CITY OF ALBUQUERQUE

**RE: Lot 13 Block 3 Unit 19 Volcano Cliffs Subd.
6515 Camino Del Oeste NW
Request for Permanent C.O. - Not Accepted
Engineers Stamp Date 7/6/16 (D10D003U13)
Certification Dated: 1/30/17**

Based on the Certification received 1/30/2017, the above mentioned residence cannot be accepted for release of Certificate of Occupancy by Hydrology until the following comments are addressed:

GRADING AND DRAINAGE PLAN

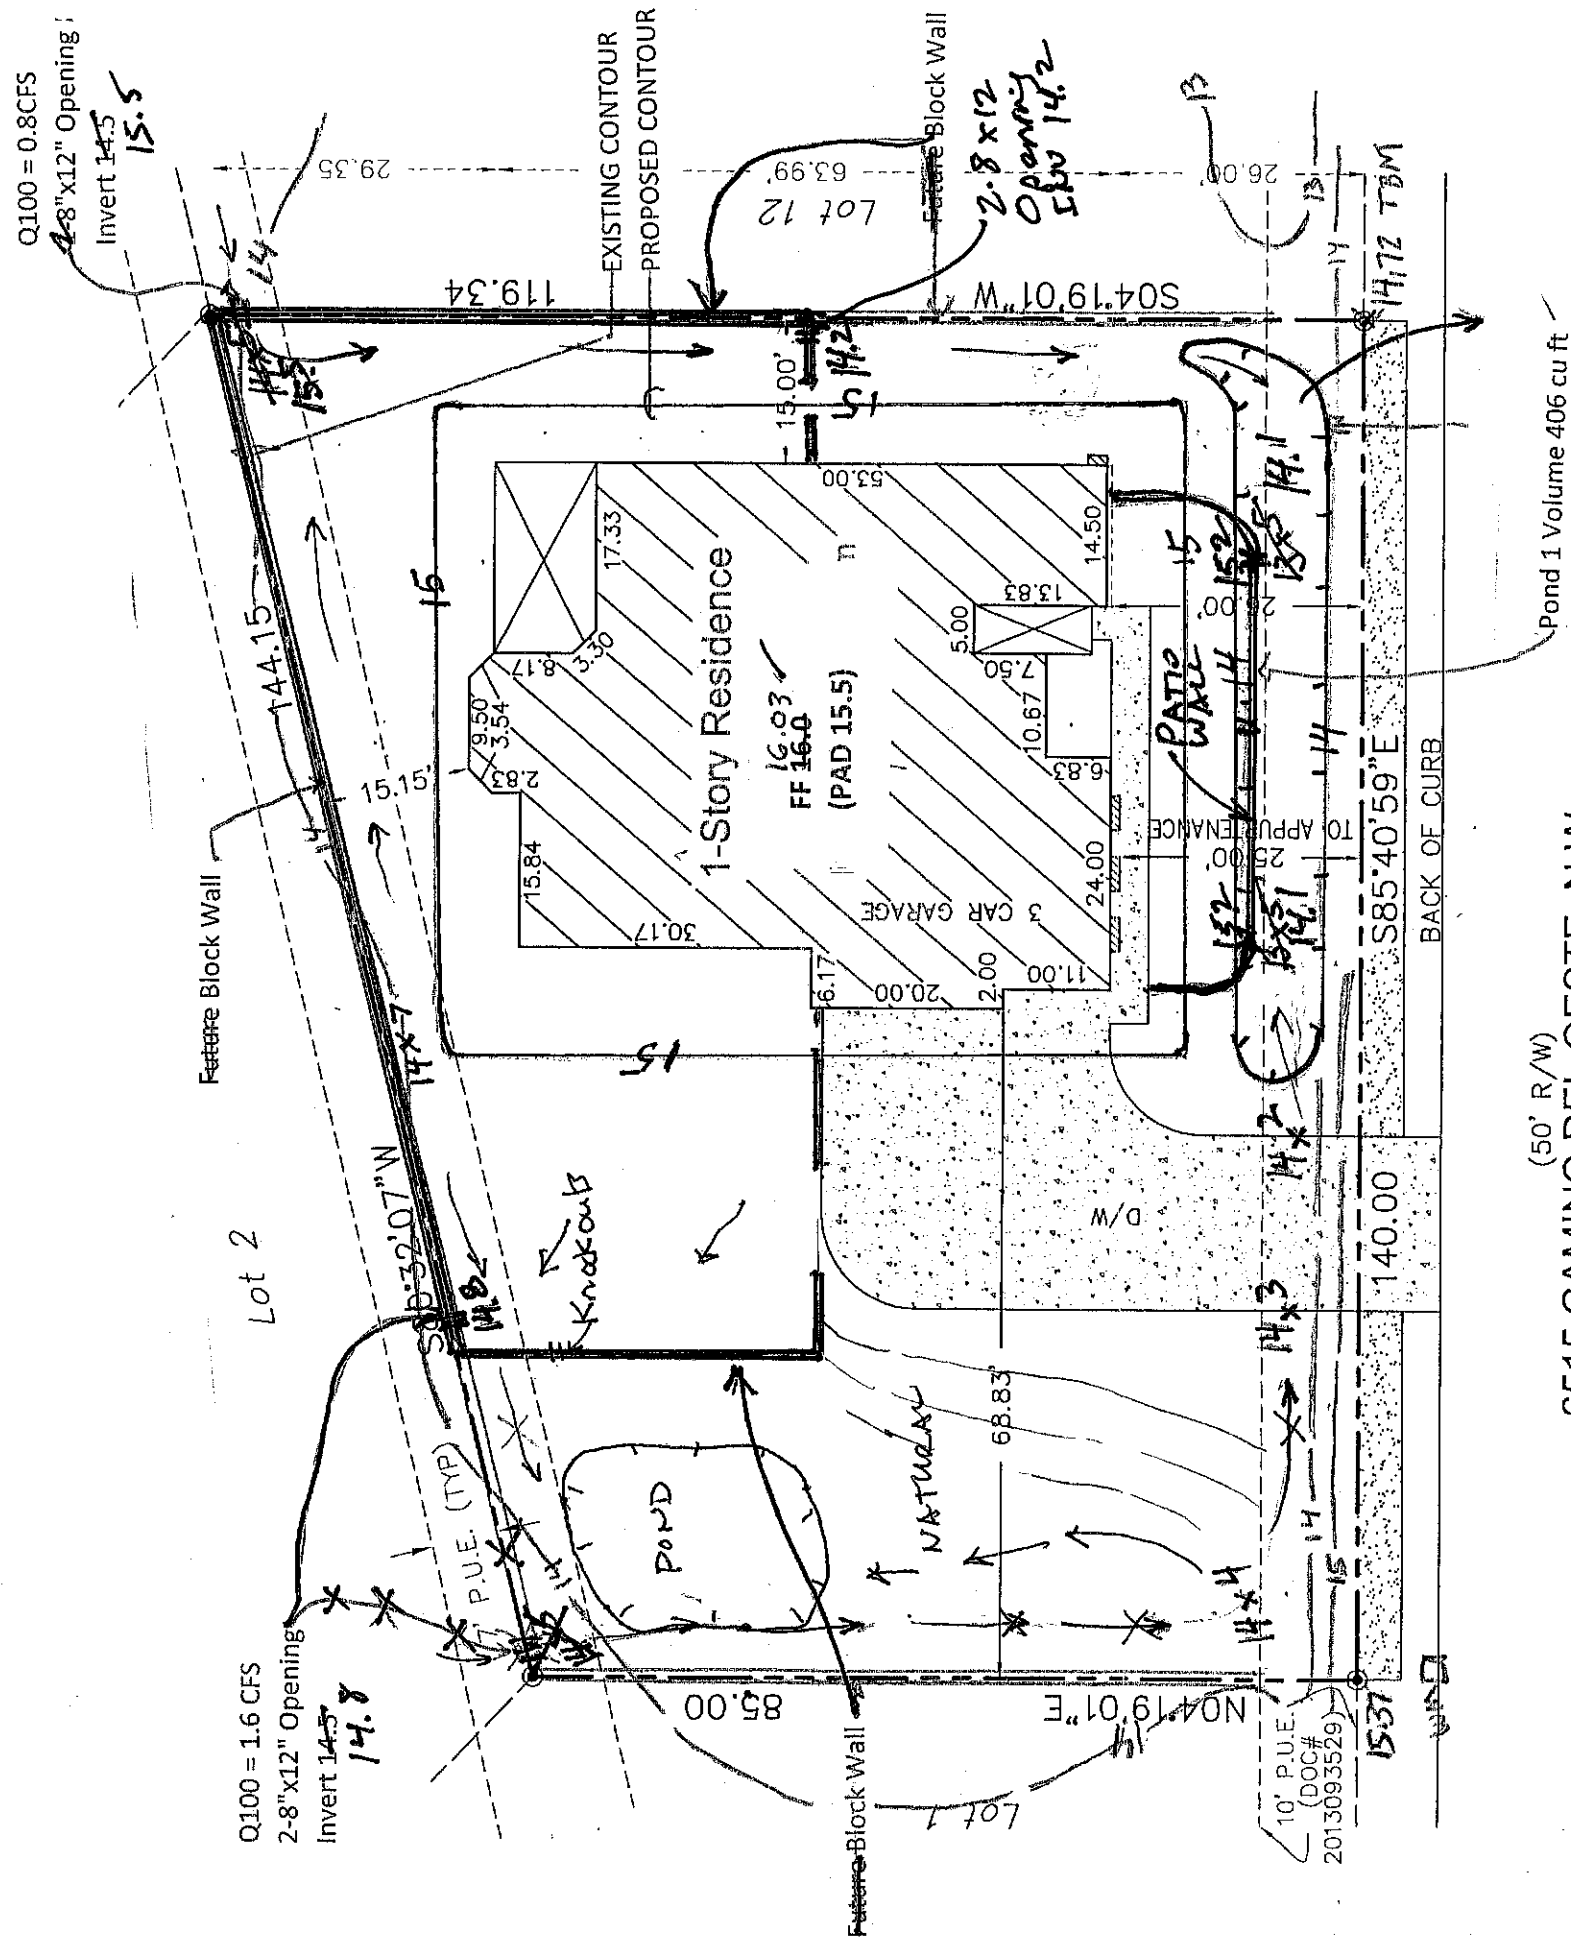
- Per the approved site plan the flow on the east side of the lot is to drain south toward the front yard pond. The lot is graded to drain north. The flows need to be reversed.
